Tel: 01903 737756
Email: planning@arun.gov.uk
www.arun.gov.uk/planning
Please ask for: Breezie Allwright
Email: breezie.allwright@arun.gov.uk
Telephone: 01903 737500
Our Ref: FG/27/26/PDH
Your Ref:
Date: 17th April 2026

Prior Notification for a Permitted Development (Householder)

Development: Notification under extended permitted development rights for proposed single storey extension to rear of existing detached bungalow and changes to fenestration.
Location: 116 Littlehampton Road Ferring BN12 6PL

Drawing	
Proposed elevations	
Issue Date 11.03.2026	CHL drawing ref. 2026-14-03c
Scale 1:100@A3

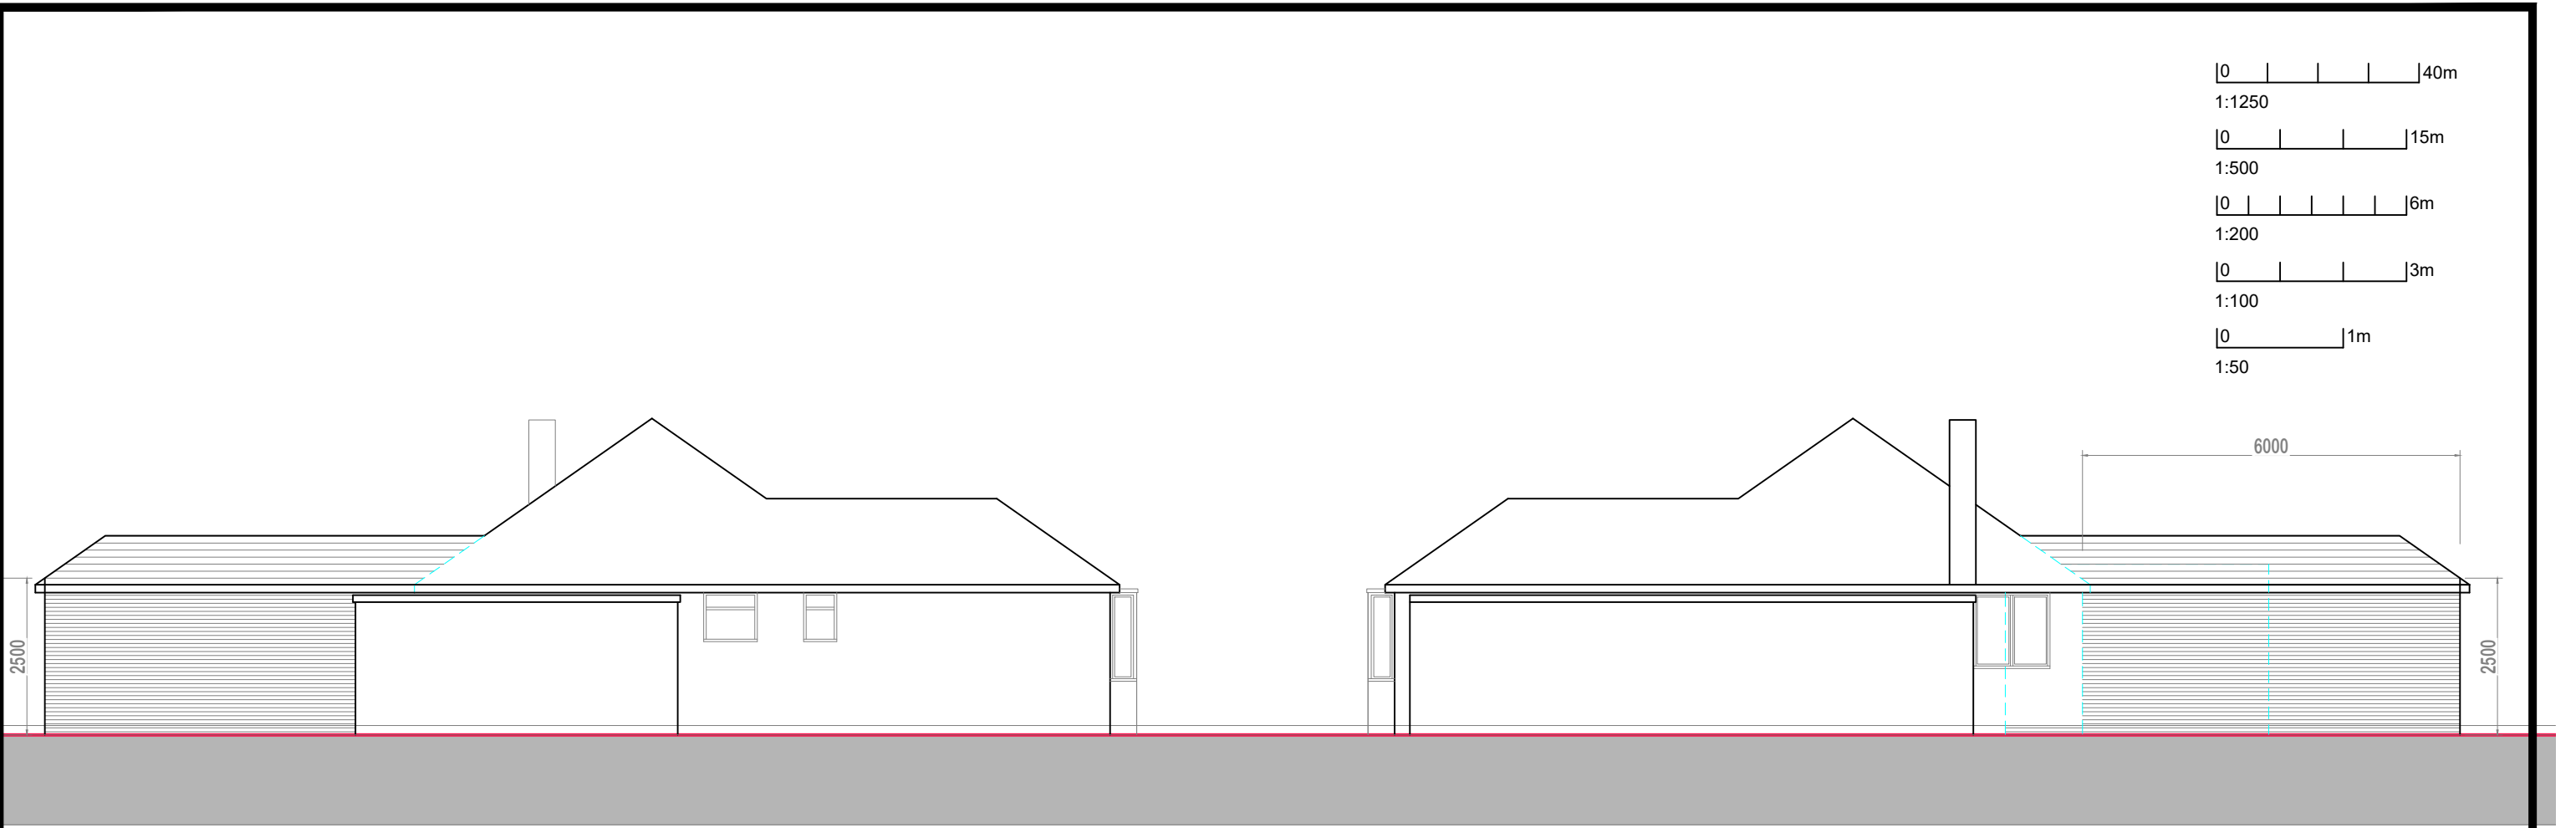
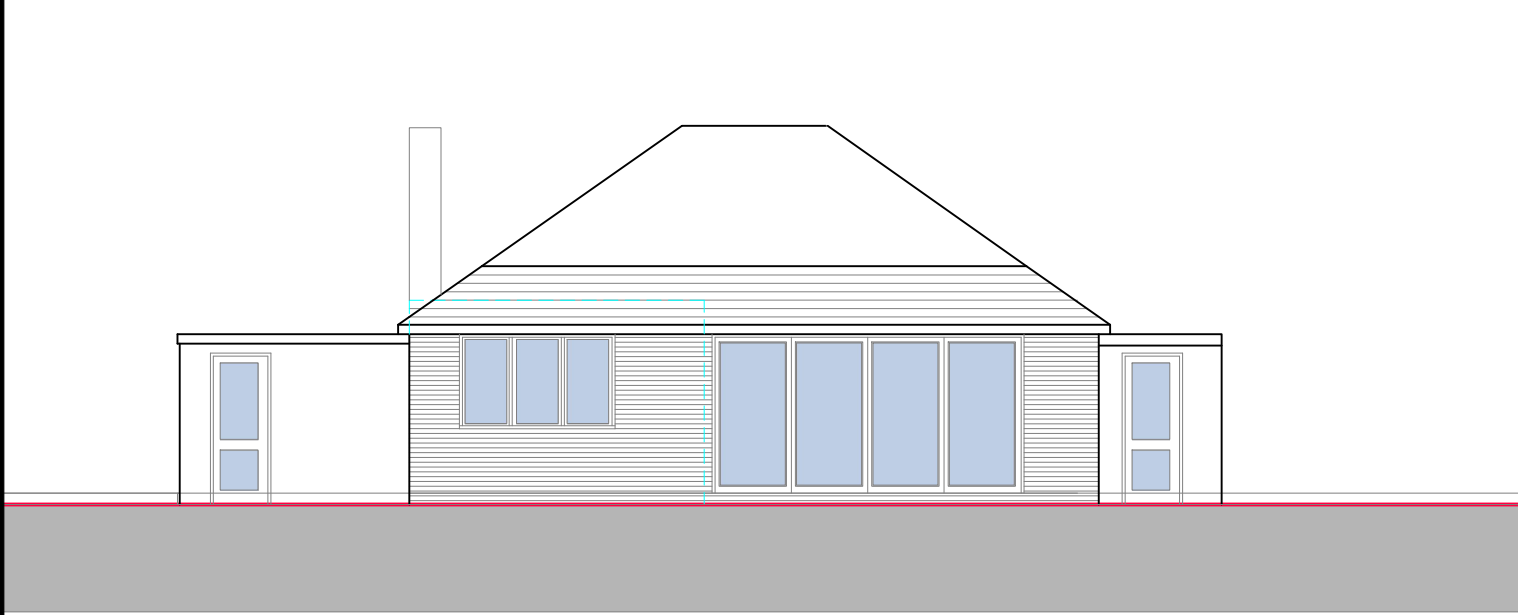
The proposed floor plan shows an additional window that is not visible on the proposed West facing elevation. Please amend accordingly.
